Recommendation Report for Planning Permission**REF NO:** R/225/13/**LOCATION:** Sainsburys Supermarkets Ltd, Unit C
New Road
Rustington Littlehampton**PROPOSAL:** Installation of transformer, generator, substation, sprinkler tank and pump house at ground floor level along with rooftop condenser units.**SITE AND SURROUNDINGS**

RECOMMENDATION

REFUSE

Proposed Substation Details

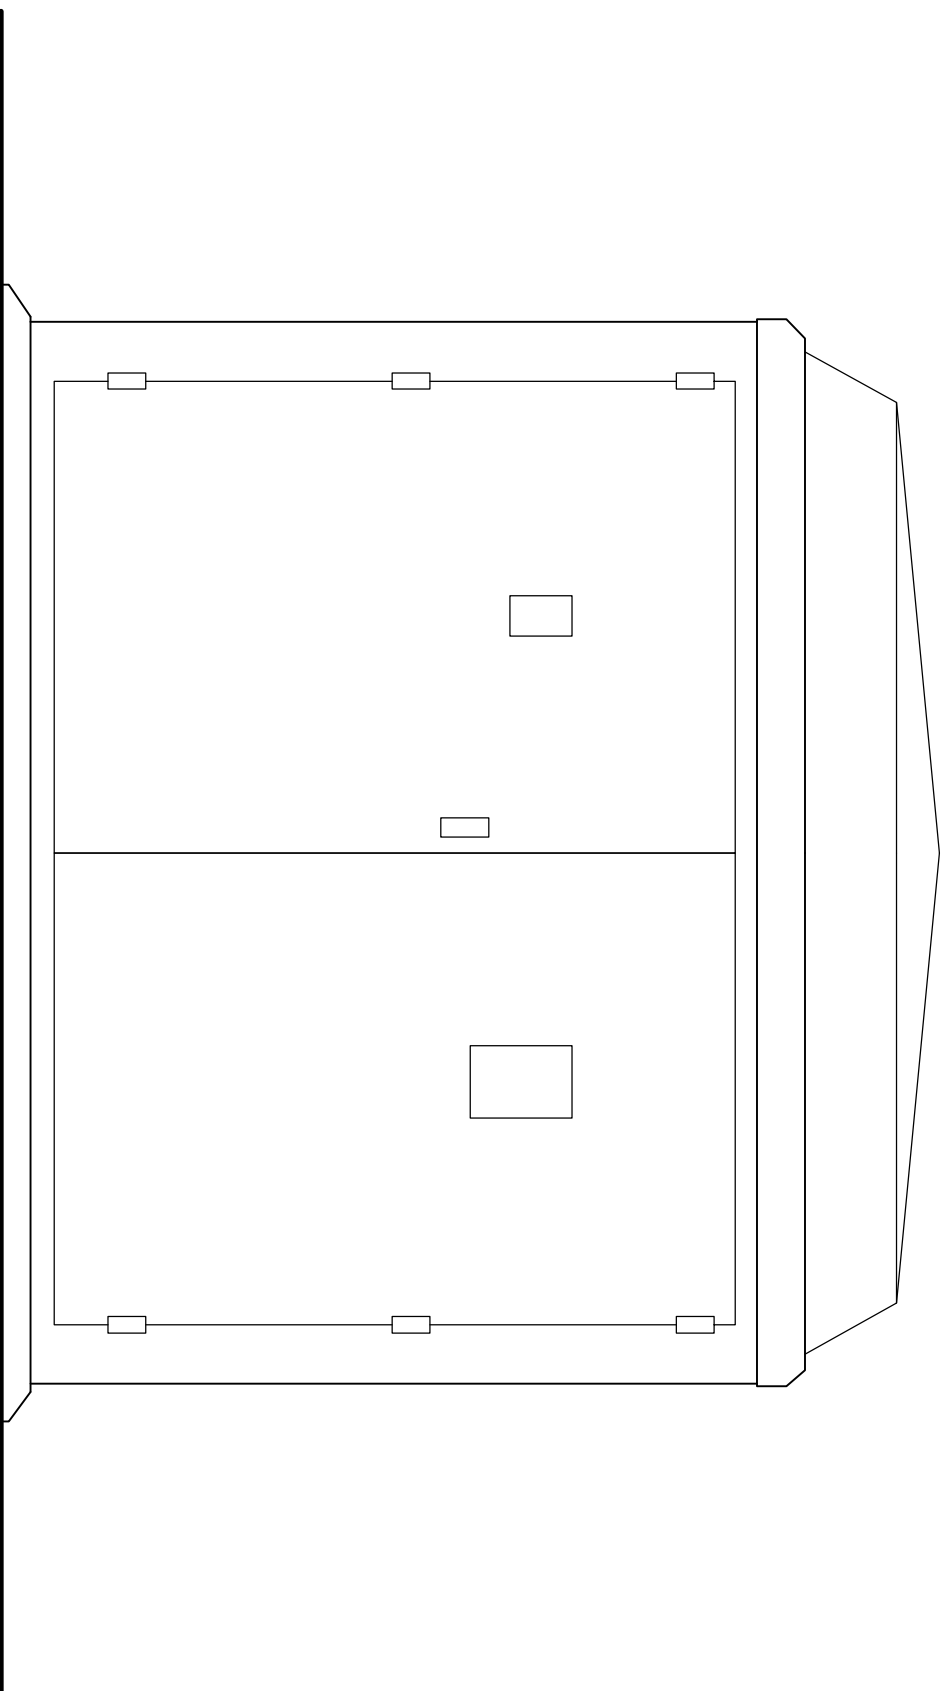
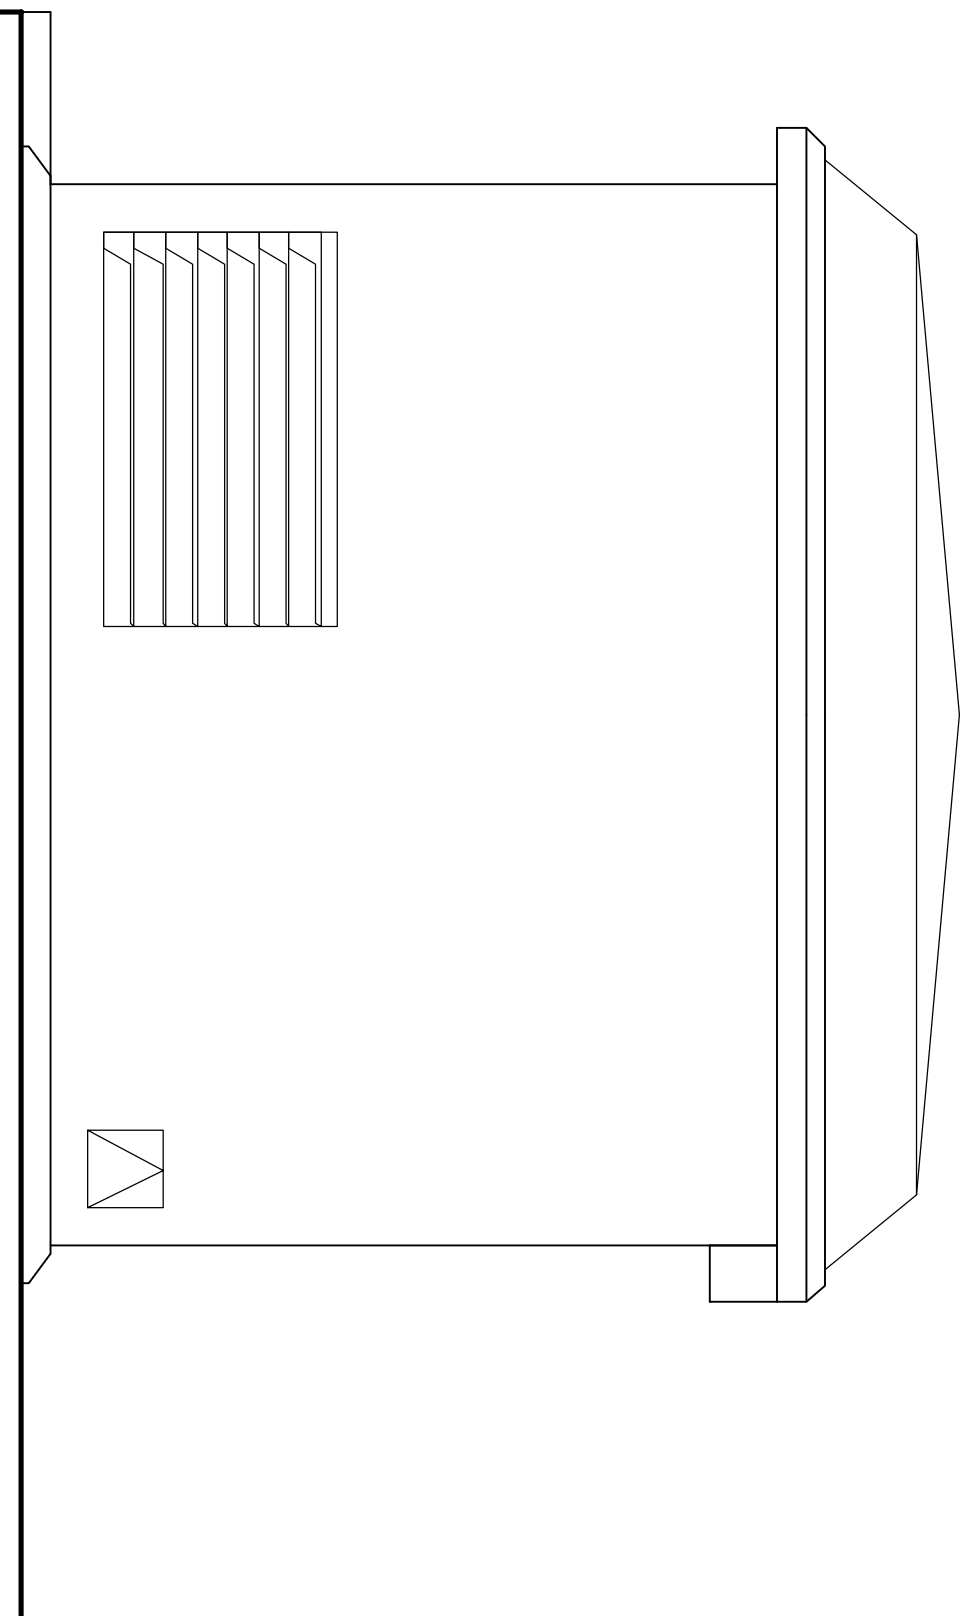
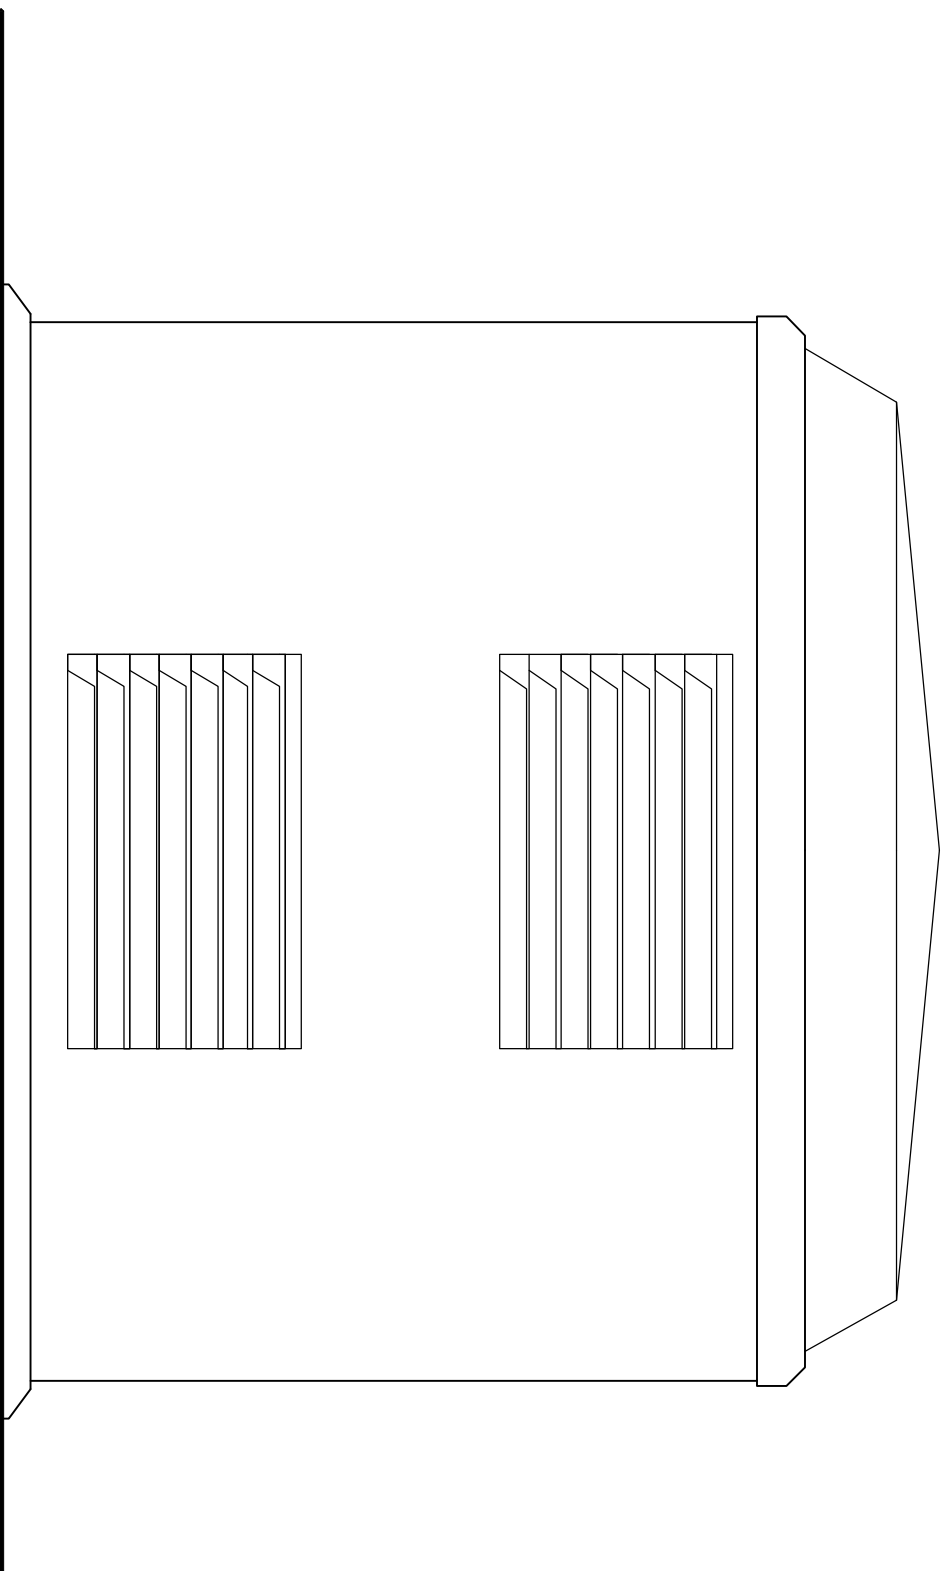
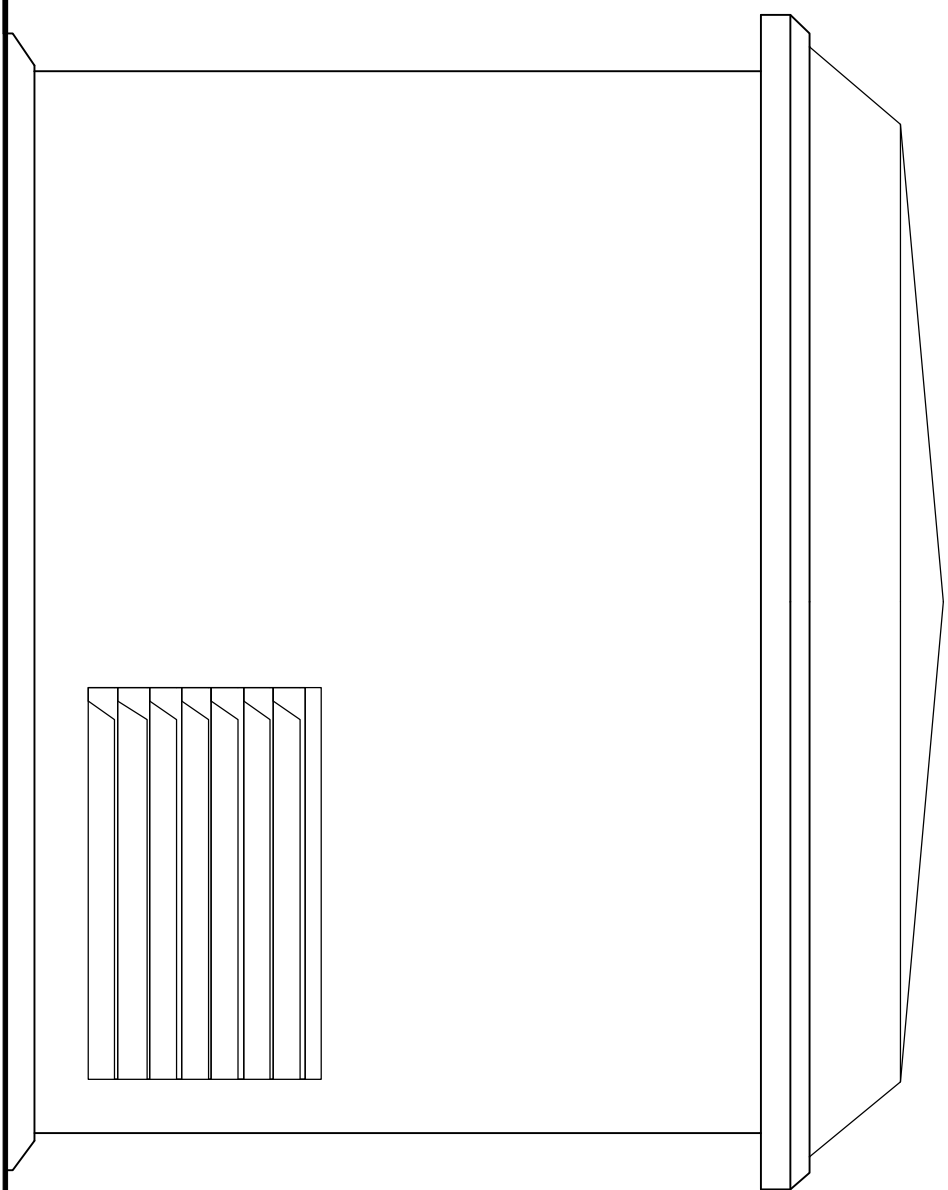
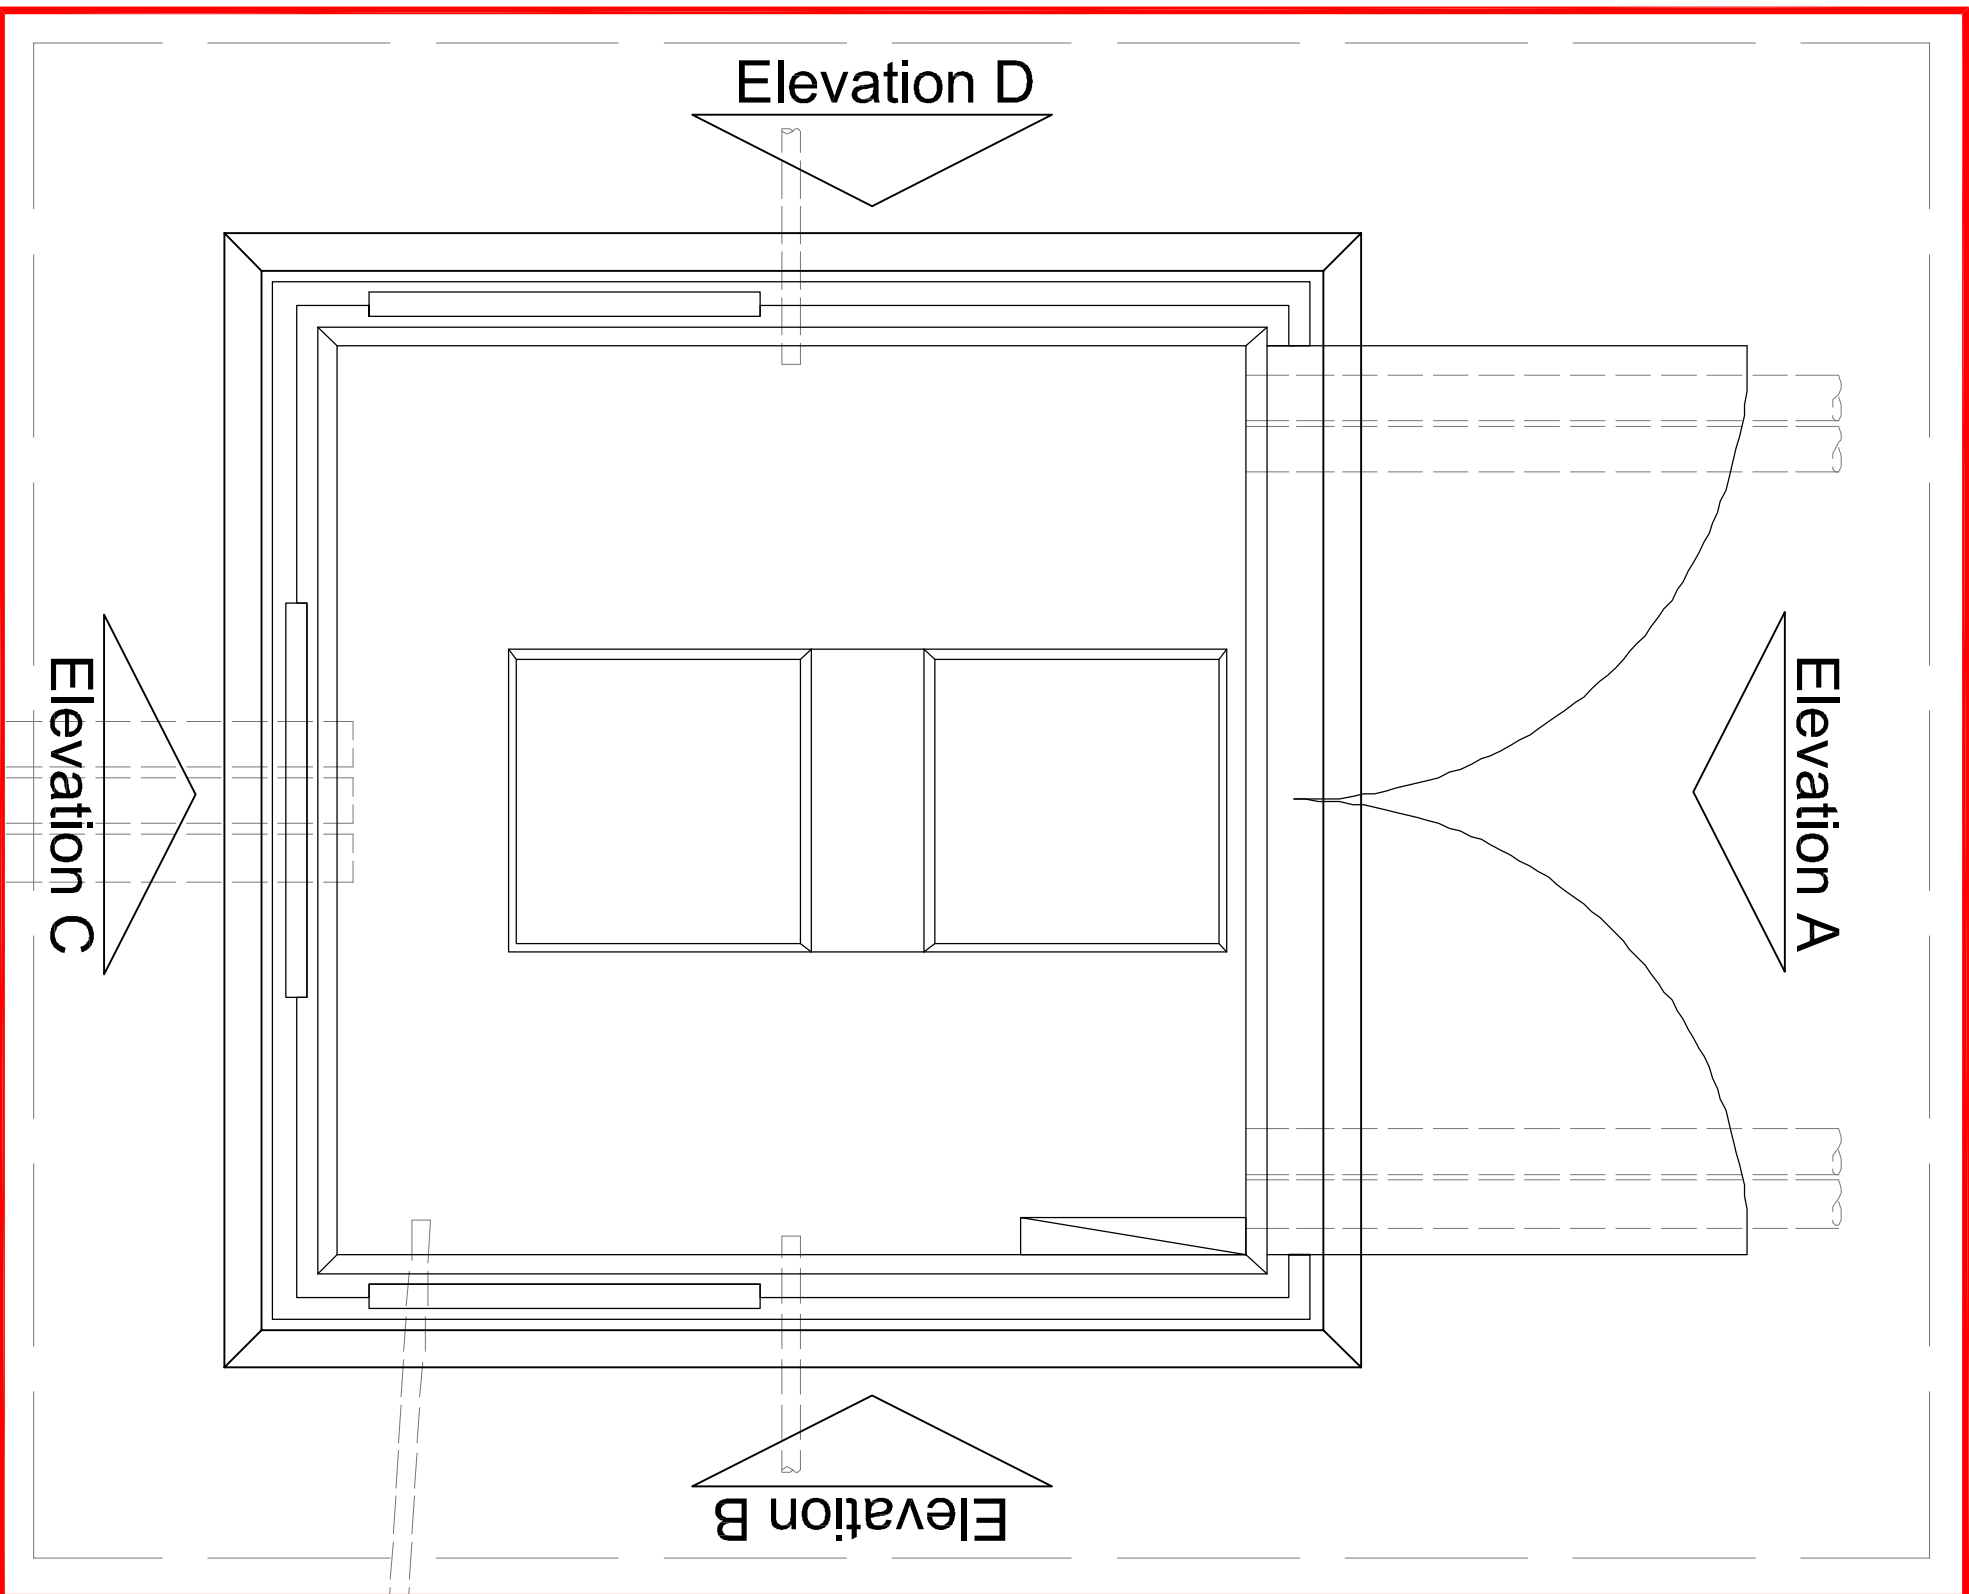
The proposed electricity substation is located within the site boundary and is not immediately visible from public areas. It is acceptable in design and appearance and will not have any appreciable impact on the character and appearance of the area. The substation is therefore considered acceptable.
